Addendum No. 2

RE: Contract # C204554

Wake County (B-5318)

BRIDGE #126 OVER SMITH'S CREEK ON SR-2044 (LIGON MILL RD) IN WAKE FOREST

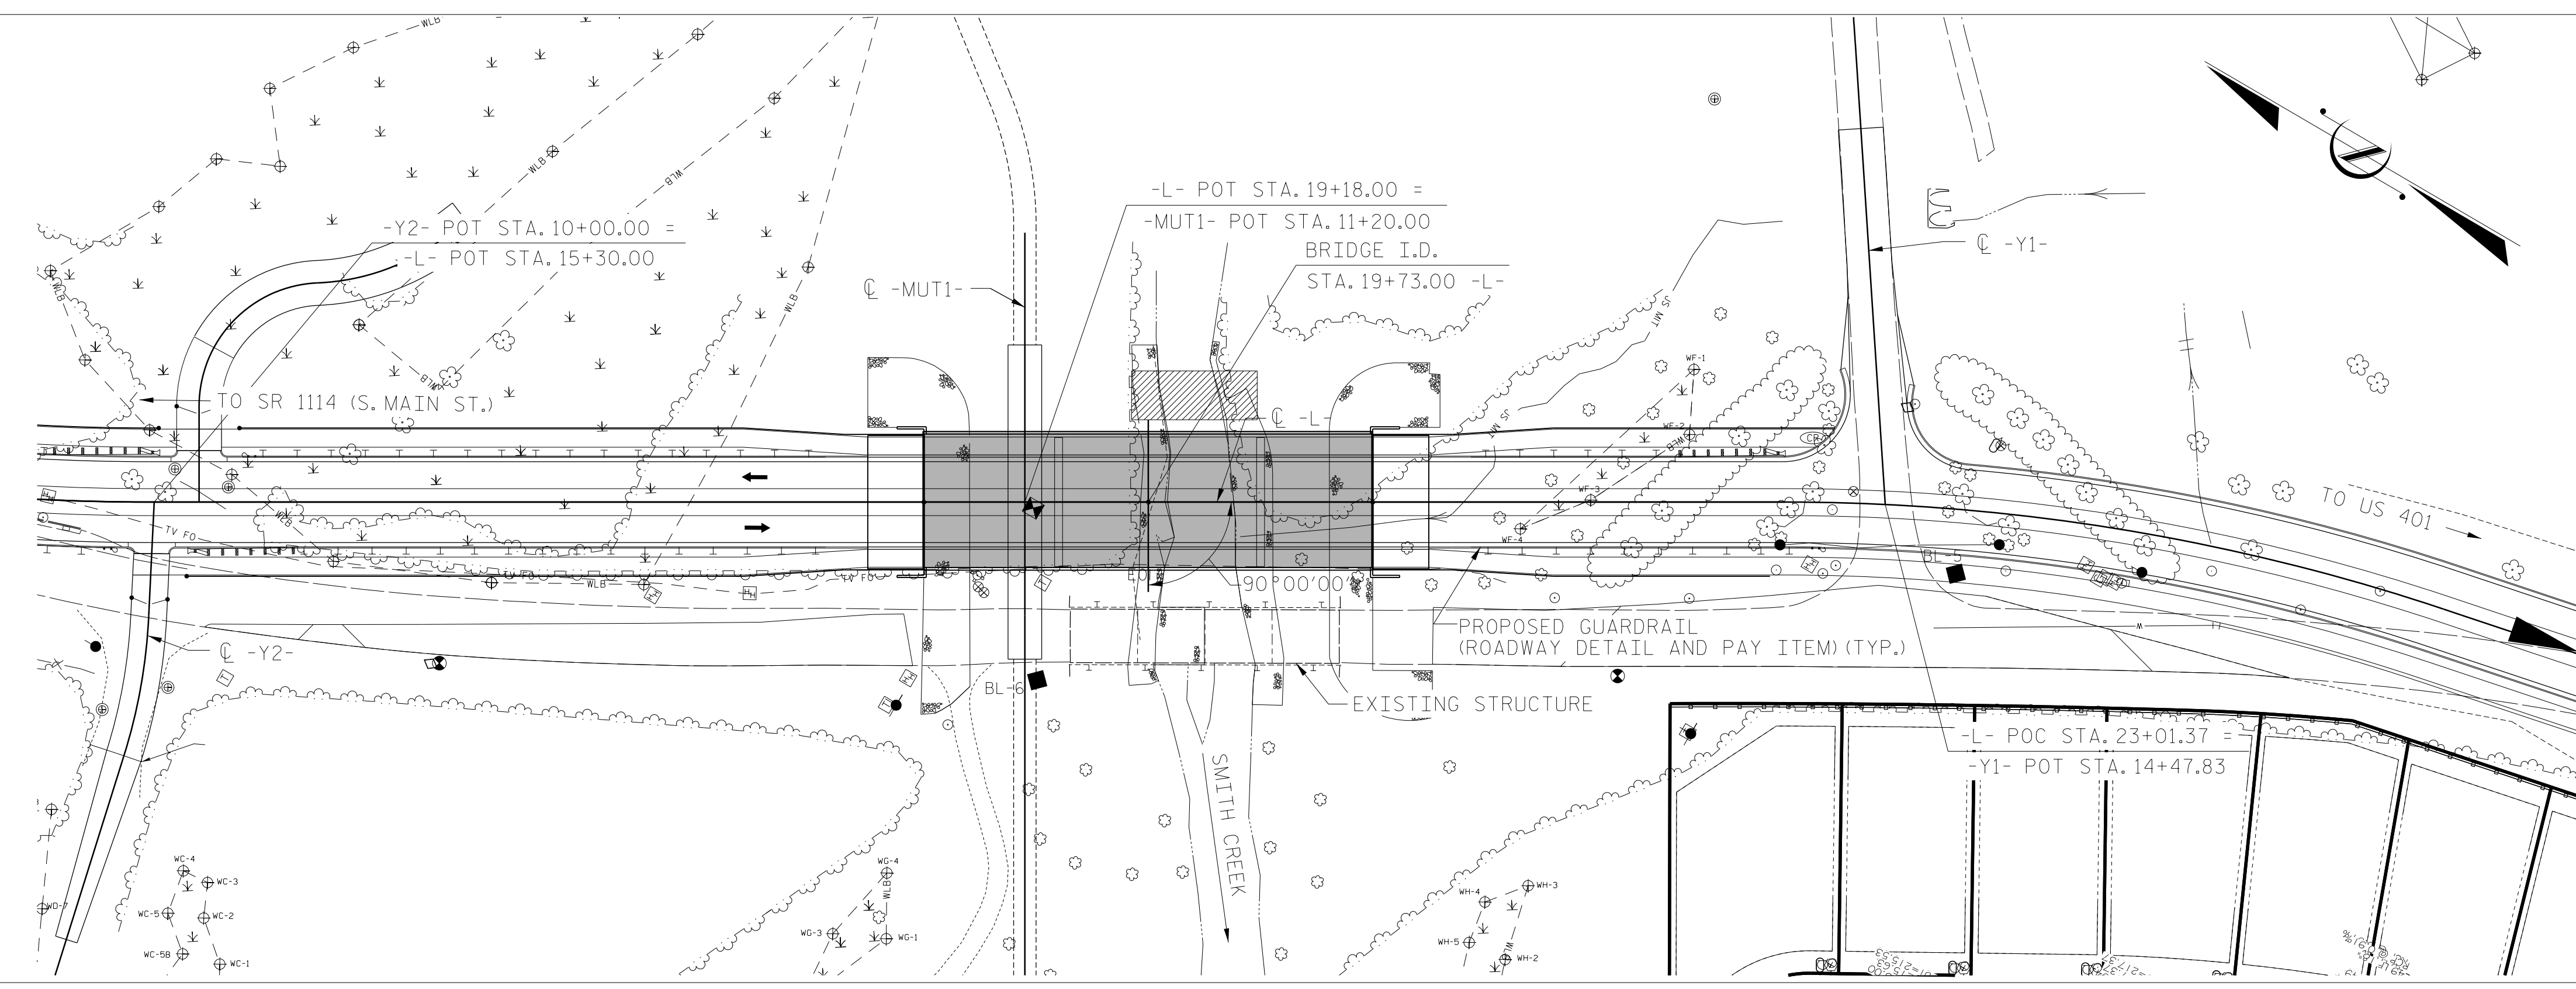
Sheet No.	Revision
S-4	Revised TOTAL BILL OF MATERIAL to reflect addition of quantity shown below

<u>Item</u>	<u>Description</u>	<u>Old Quantity</u>	<u>New Quantity</u>
0129-6029000000-E-SP	SAFETY FENCE	1,120 LF	1,950 LF
0173-8391000000-N-450	STEEL PILE POINTS	NEW ITEM	20 EA
